Tour Ref :2021/93444

Newlands Hall ,93 High Street ,Heckmondwike WF16 0AL
Erection of 10 Bedrooms and associated works.

*******OBJECTION/PETITION*******

PROPOSED PLANS AND ELEVATIONS

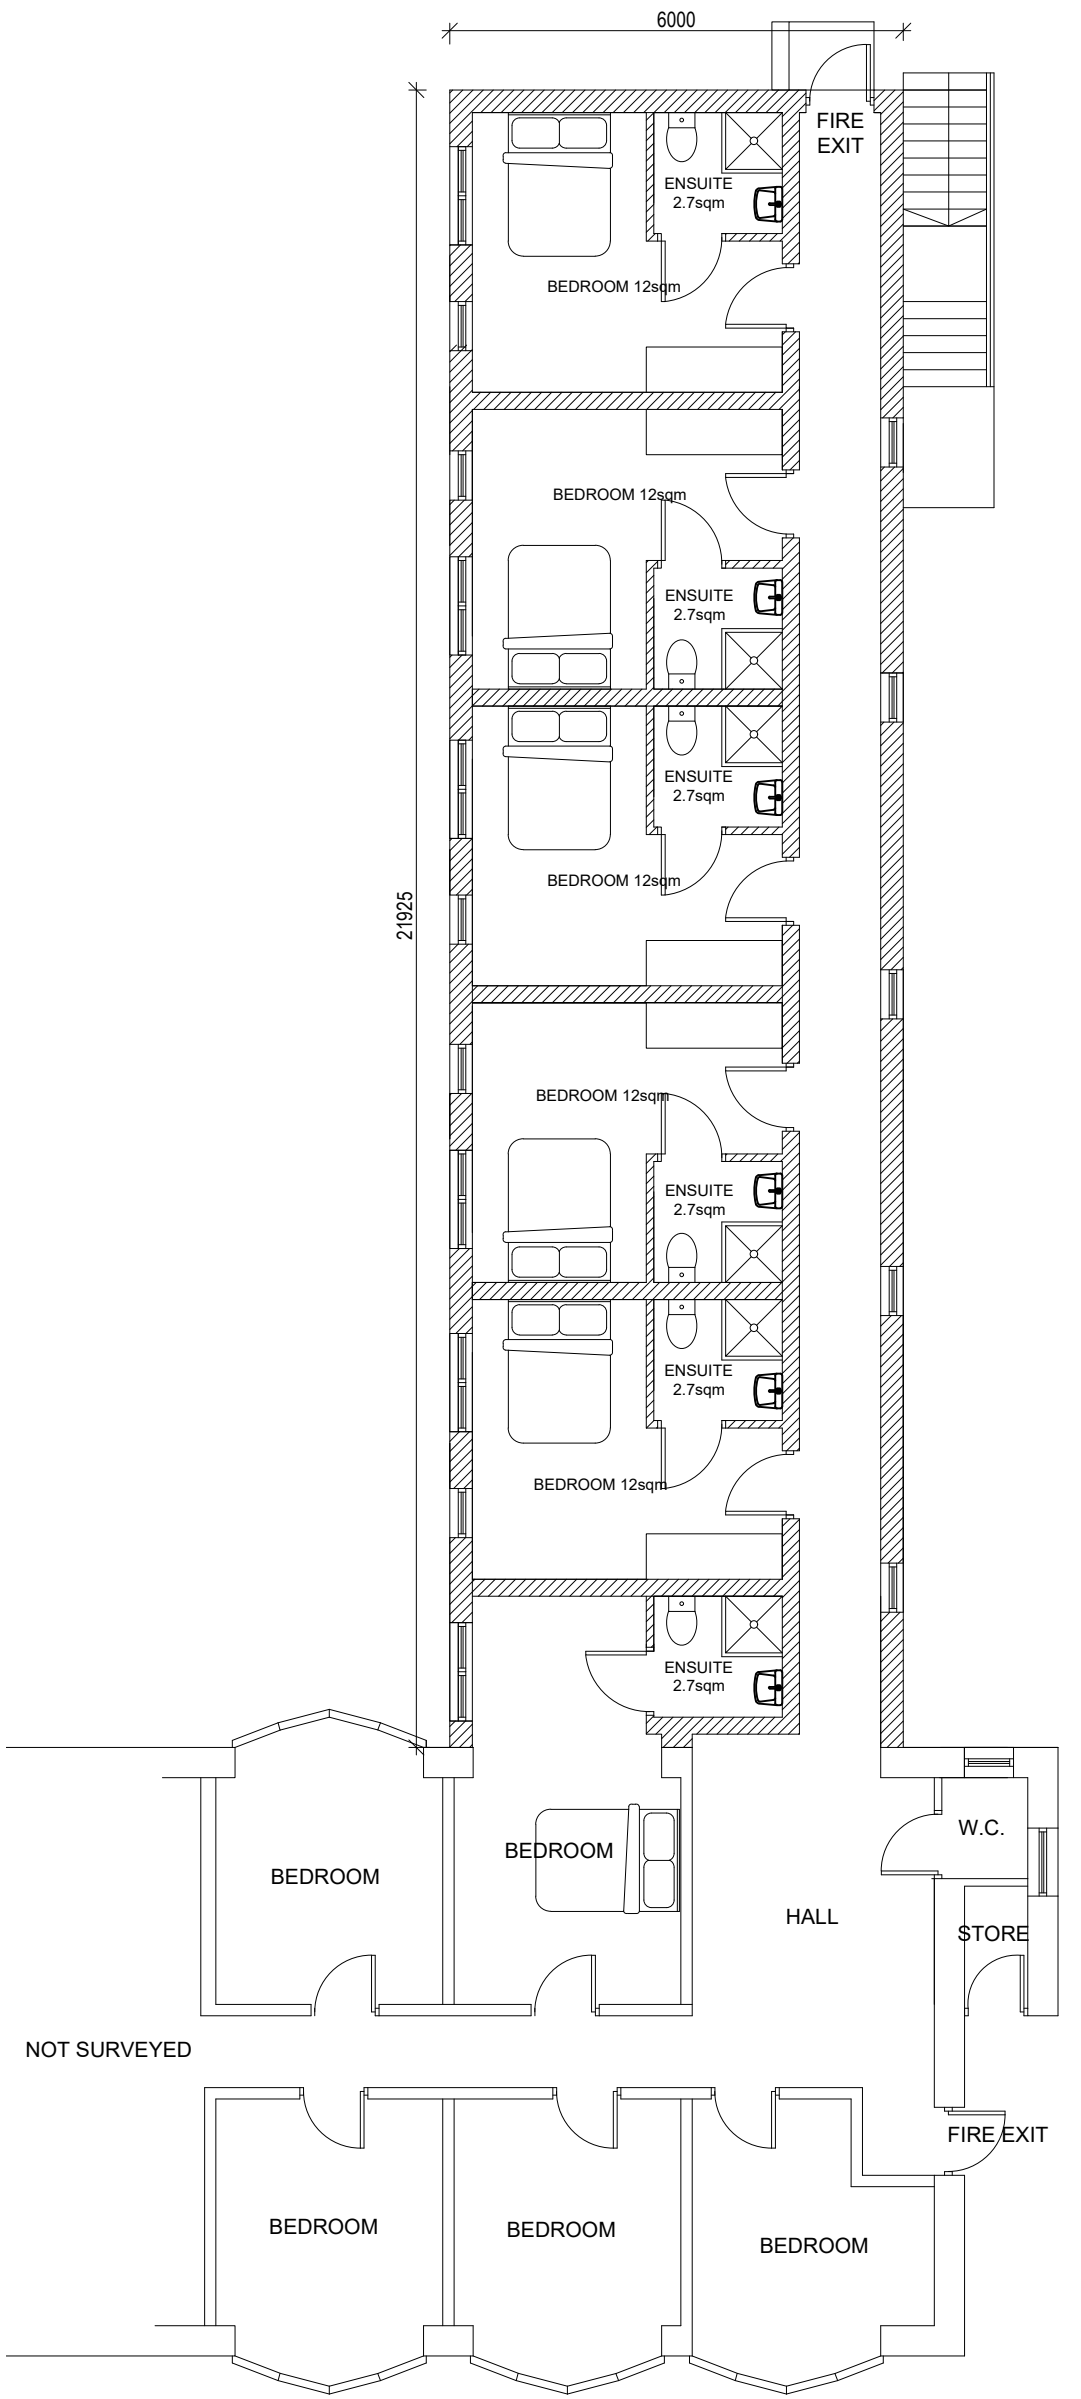
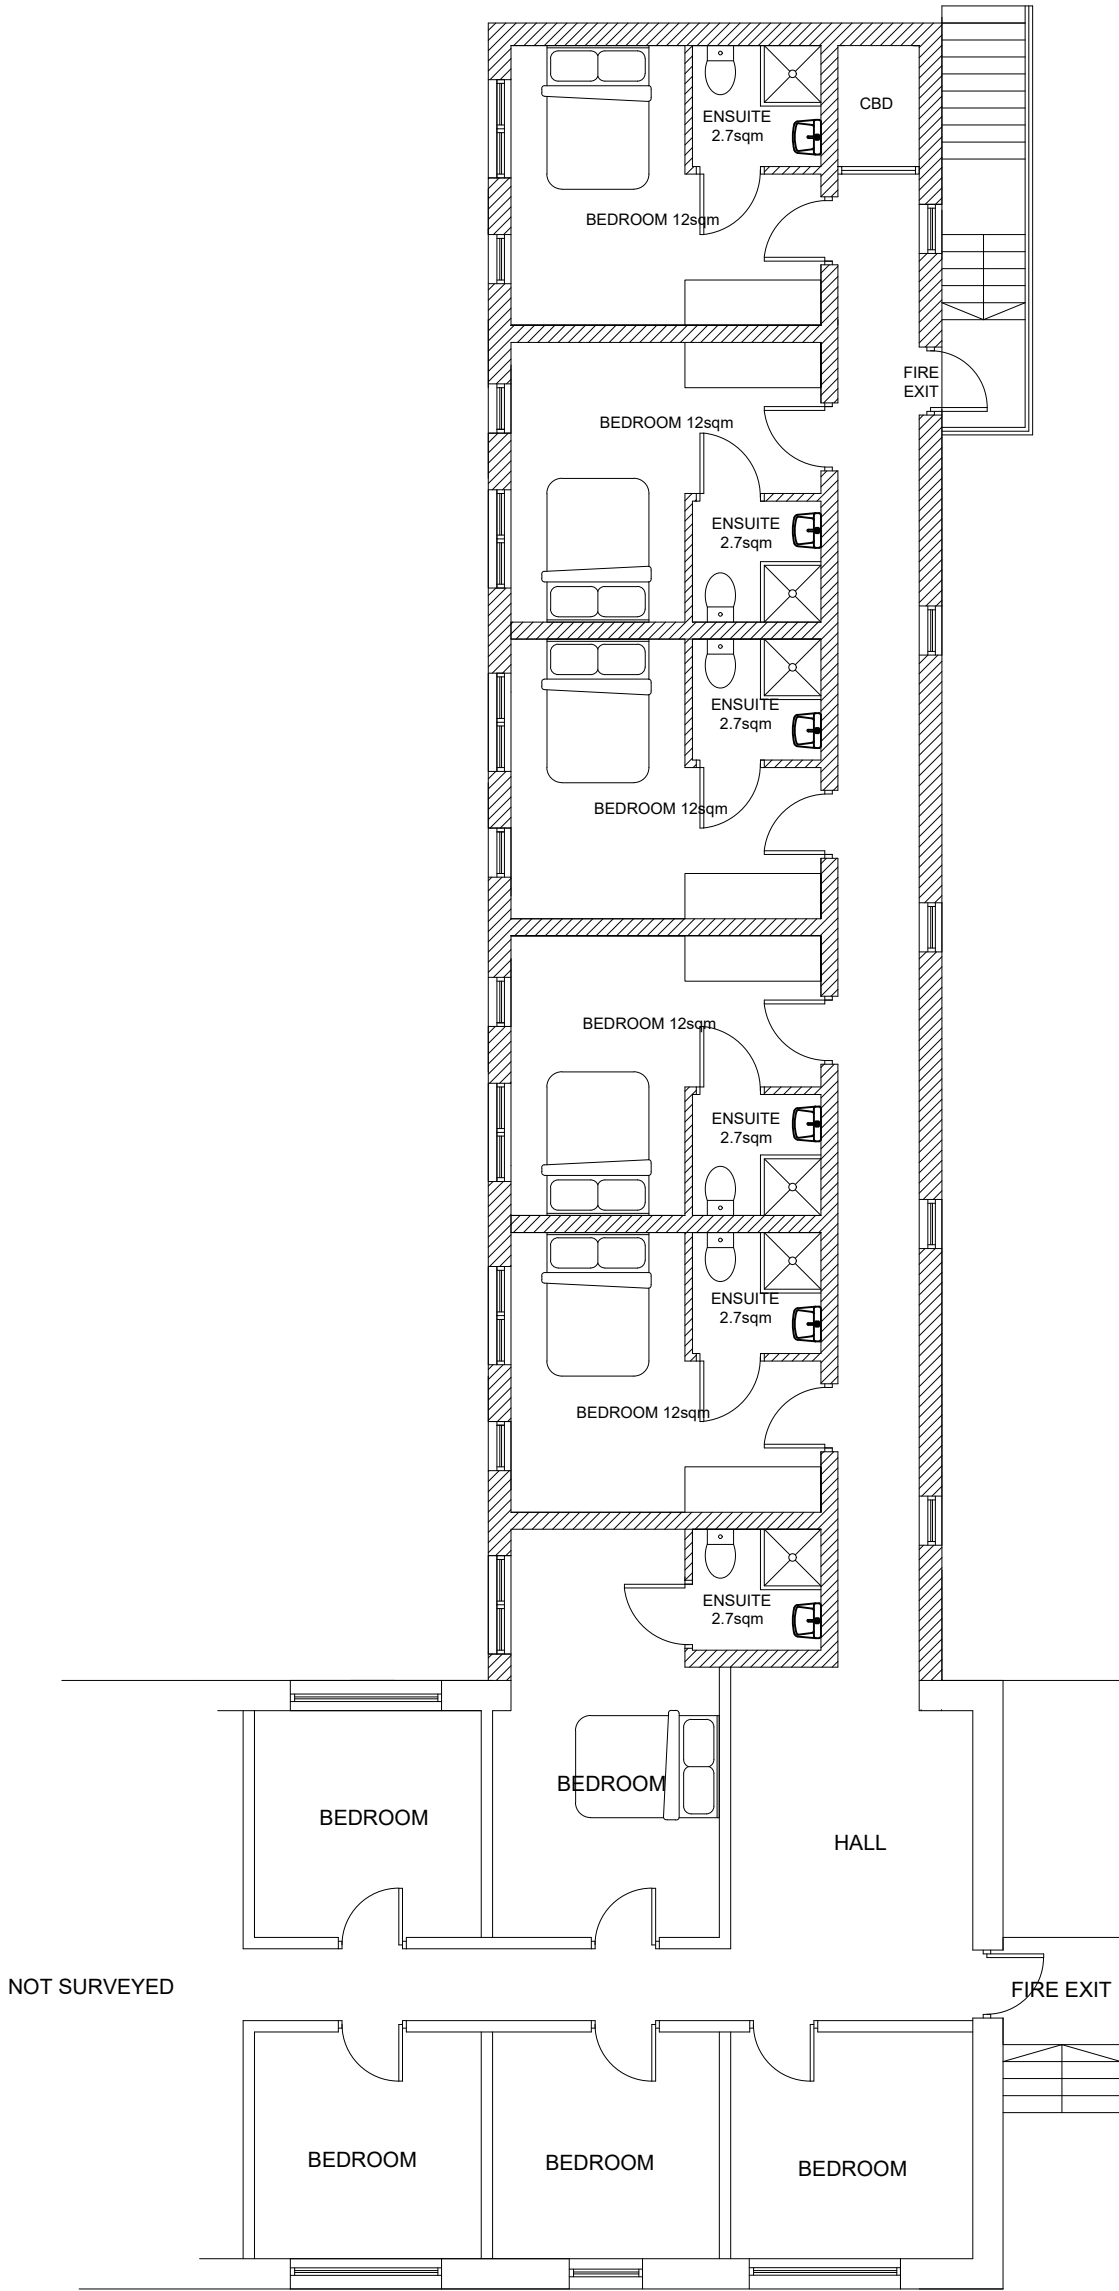
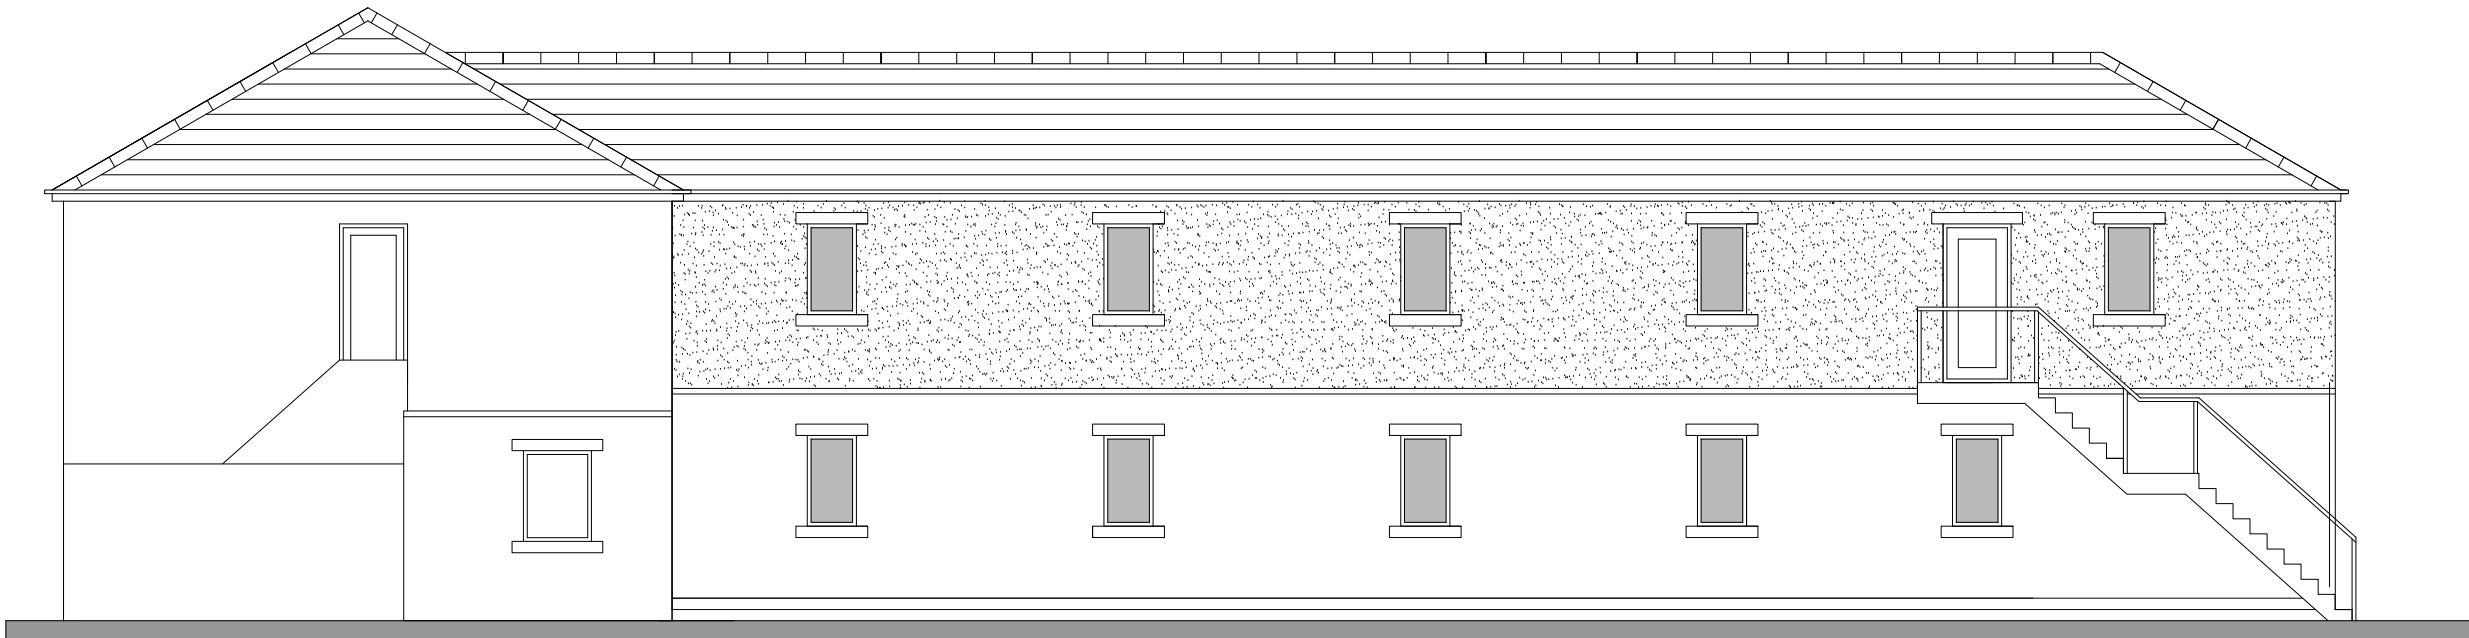
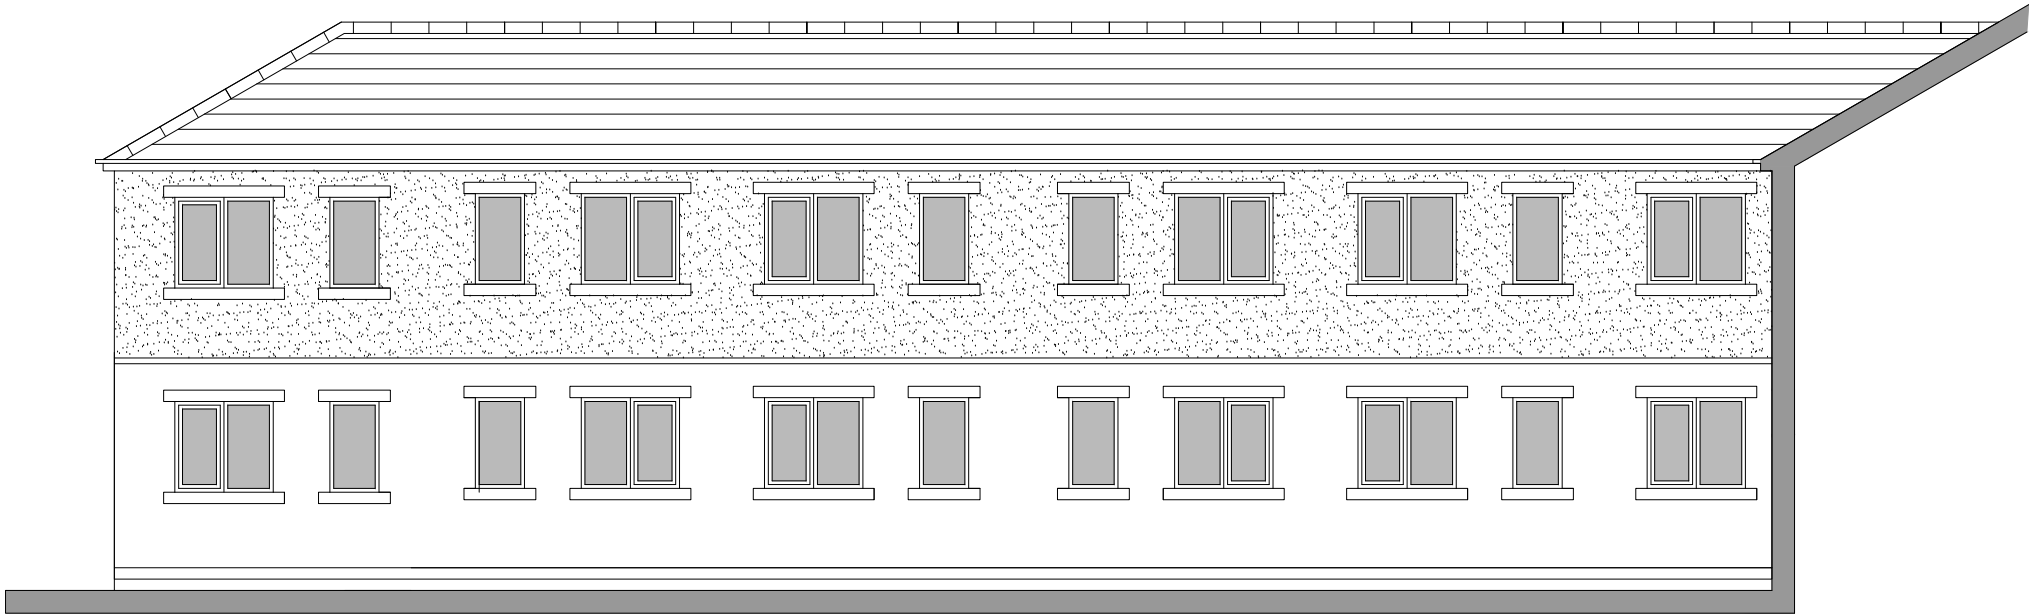
When looking at the submitted plans the gap between the new build and the current properties is very narrow and our understanding is that this goes against current planning laws which state that there has to be 22m line of site between windows and the current buildings on either side.
